24 May 2022

File No: NTH20/00301/05
Your Ref: SSD-10807896

**RE: REVIEW OF ENVIRONMENTAL IMPACT STATEMENT (SSD-10807896)
THUNDERBOLT ENERGY HUB (STAGE 1 – WIND FARM) – NEW ENGLAND HIGHWAY, KENTUCKY**

Figure 1: Haulage route

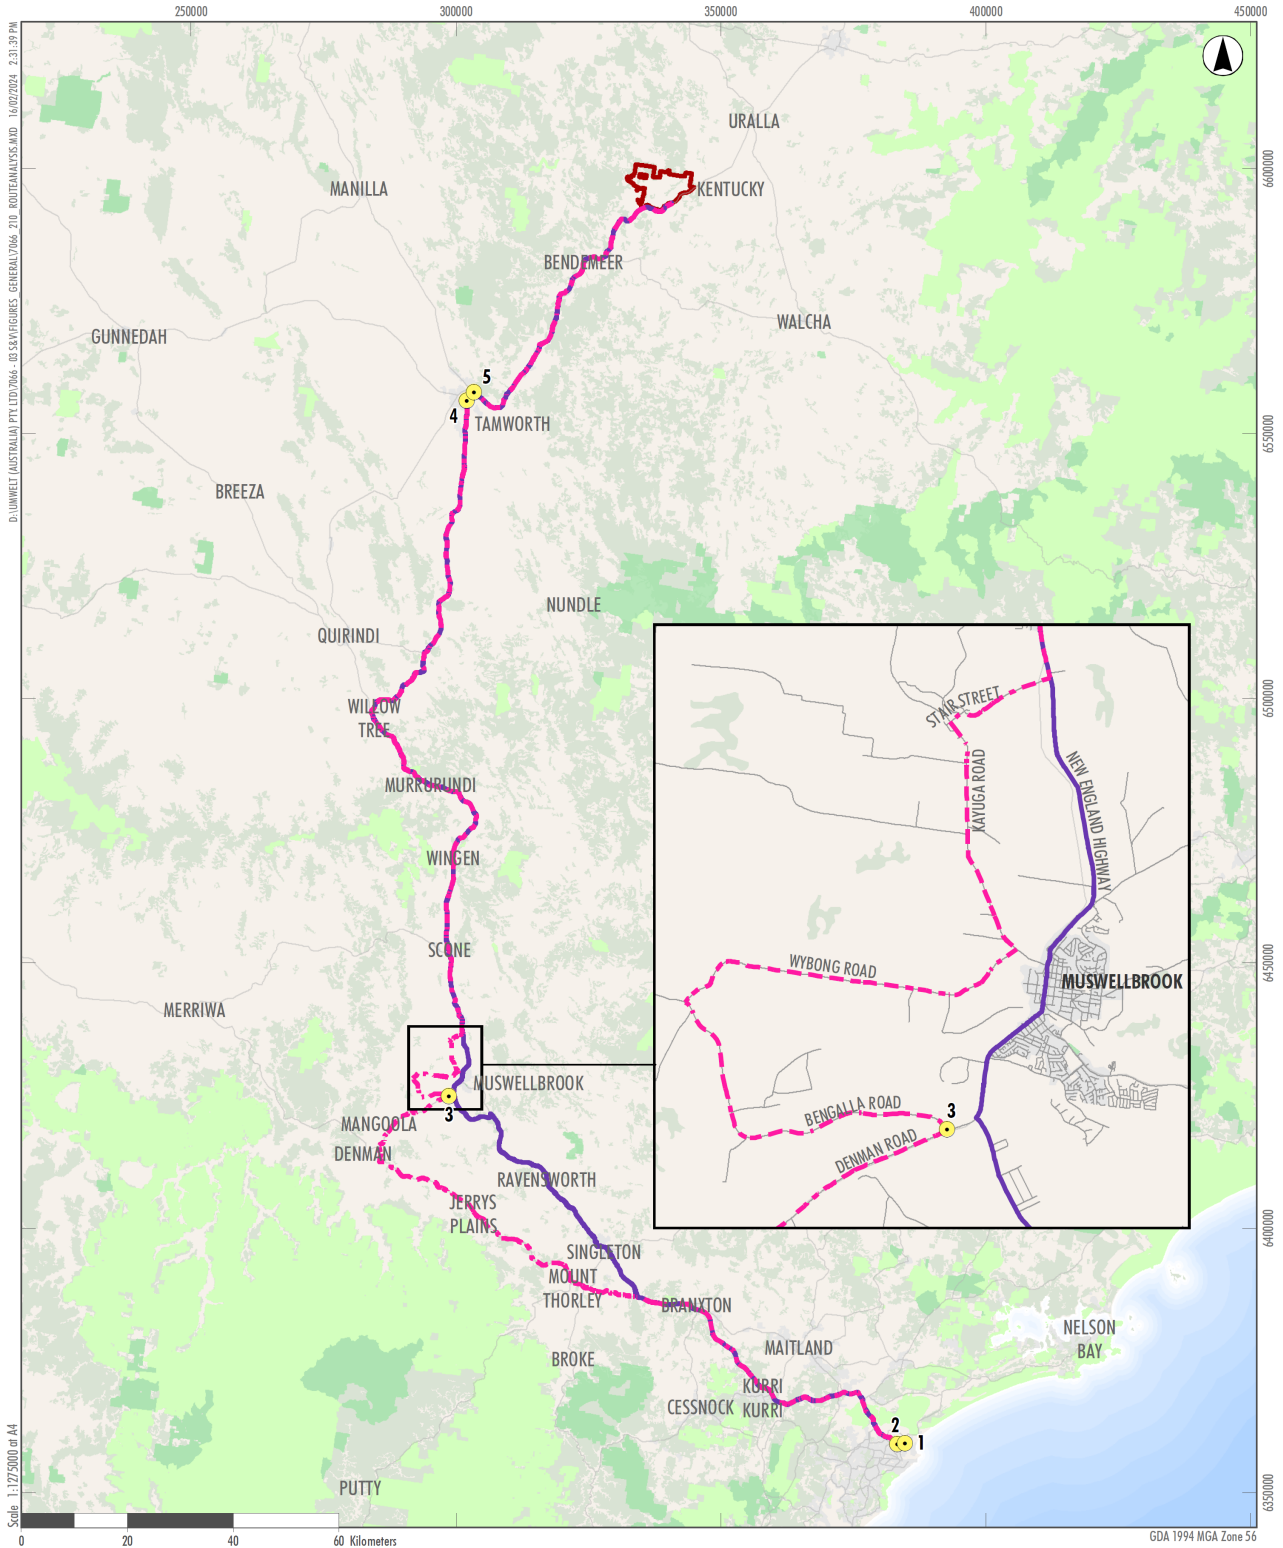
2. The *Preliminary Transport Route Assessment* in *Appendix A* of the TTIA identifies a potential conflict with a rail over road bridge in Muswellbrook for the blade component/s. the EIS should further clarify how this will resolved to confirm whether any works are required.
3. Any roadwork on classified (State) road will require TfNSW consent. Works are to be designed and constructed in accordance with the current *Austroads Guidelines, Australian Standards and [TfNSW Supplements](#)*.

6. The *Preliminary Transport Route Assessment* in *Appendix A* of the TTIA presents 2 x OSOM Turbine Component Transport Routes from Newcastle to Thunderbolt Energy Hub (Stage 1) and based on the proposed transport schedule the maximum number of Project vehicles per day on the road links forming the turbine transport routes is 18vpd (including 6 x OSOM transport vehicles and 12 x light escort vehicles). It is important for UGLRL on behalf of TfNSW to confirm that the increased OSOM movements do not have any adverse impacts on the overbridges being investigated for the transport route/s.

TfNSW Recommends the Consent Authority require the Proponent to obtain OSOM assessment / approval from UGL Regional Linx (UGLRL) on behalf of TfNSW for movements on existing overbridges over the Country Regional Network (CRN) rail corridor. The Proponent is advised to contact UGLRL's third party works team via thirdpartyworks@uglregionallinx.com.au for approval.

Route Analysis

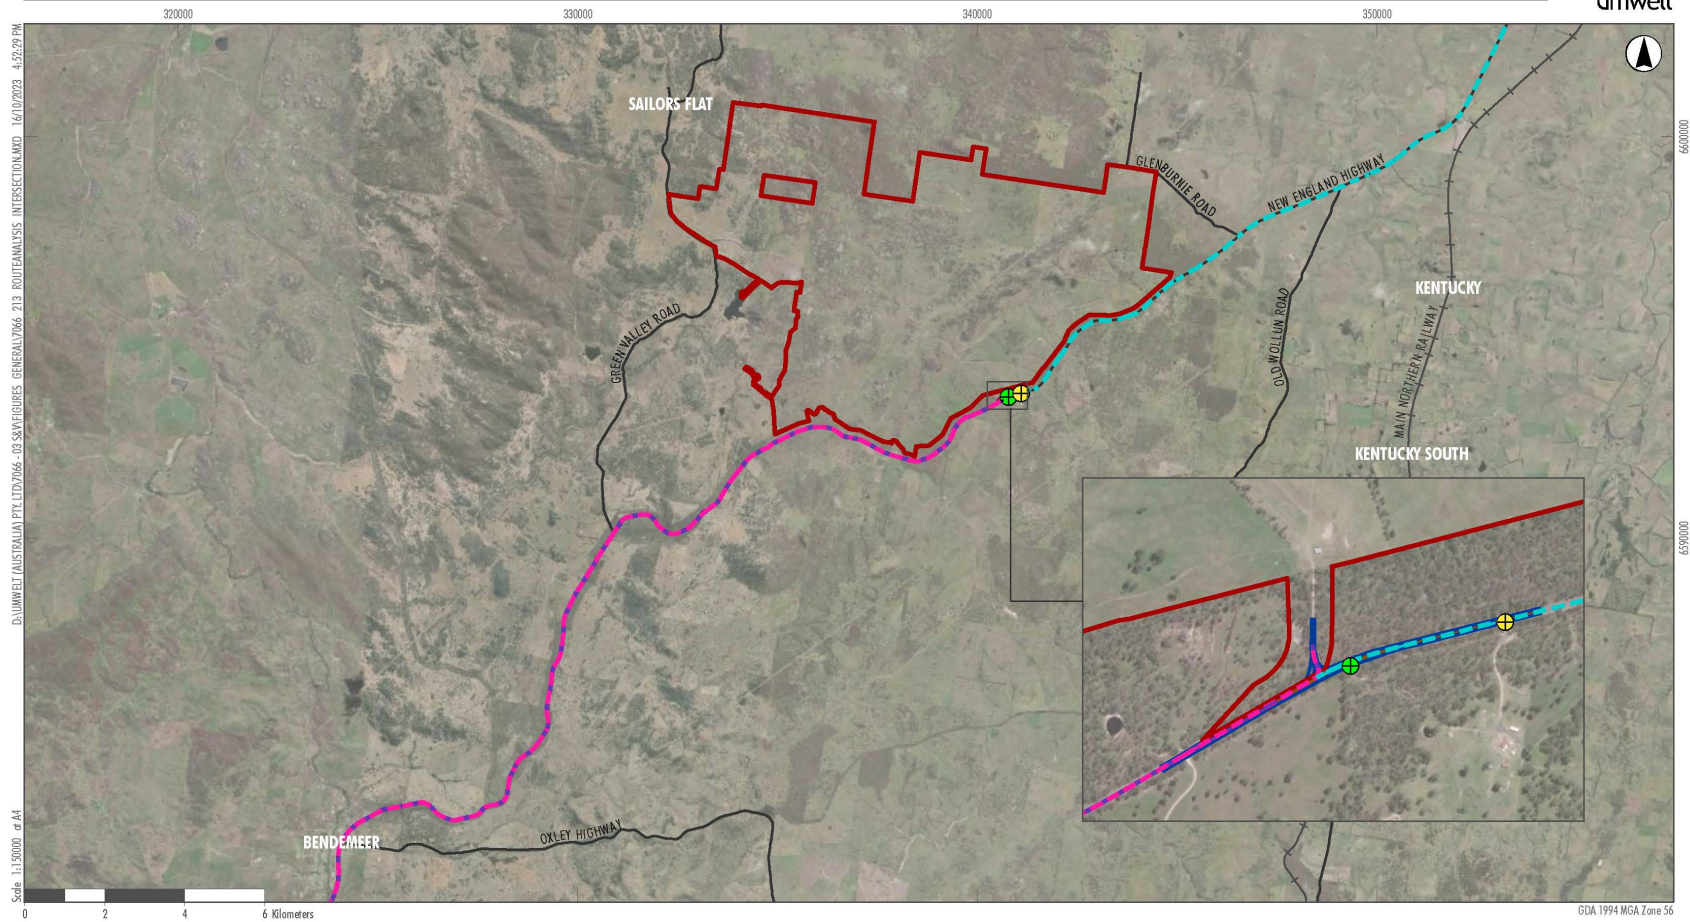
1. The proposed Site Access design identified in (*Appendix D of the TTIA – Preliminary Site Access Intersection Layout*) demonstrates a basic left turn (BAL) & short channelised right turn (CHRs) arrangement, based upon an assessment of the Austroads Turn Warrants for access demand during the peak periods.

Whilst TfNSW supports the installation of turn treatments to enable safe access for development traffic, the EIS needs to give further consideration to the impact of these treatments on the existing rural property access opposite the site access location. In particular, the proposed arrangement will require vehicles entering and leaving the rural property to turn across the proposed channelised right turning lane.

The proposed arrangement is made complex by an increase in heavy vehicle movements, topographical constraints, speed environment, road geometry and roadside drainage & trees. The EIS suggests sight-distance may be constrained at the site access, however it is also stated in the TTIA that, “*there is not any particular existing road feature or design deficiency which is likely to be contributing to crashes in the vicinity of the Project Area*”. TfNSW notes that, cross-road intersections or property accesses which are closely staggered, increase the potential for vehicular conflict, in particular where there is opposing heavy vehicle movements and constrained sight distances.

TfNSW recommend the *Preliminary Site Access Intersection Layout* in *Appendix D* be updated to include a 3D plan including cross sections and long sections. For further details see TfNSW Strategic Design Requirements for DAs [here](#).

TfNSW further recommend consideration may need to be given to the need to relocate the proposed development access and / or the rural property access located opposite. It would be helpful to understand the existing rural uses associated with each property access, including the frequency and type of vehicles utilising these accesses.
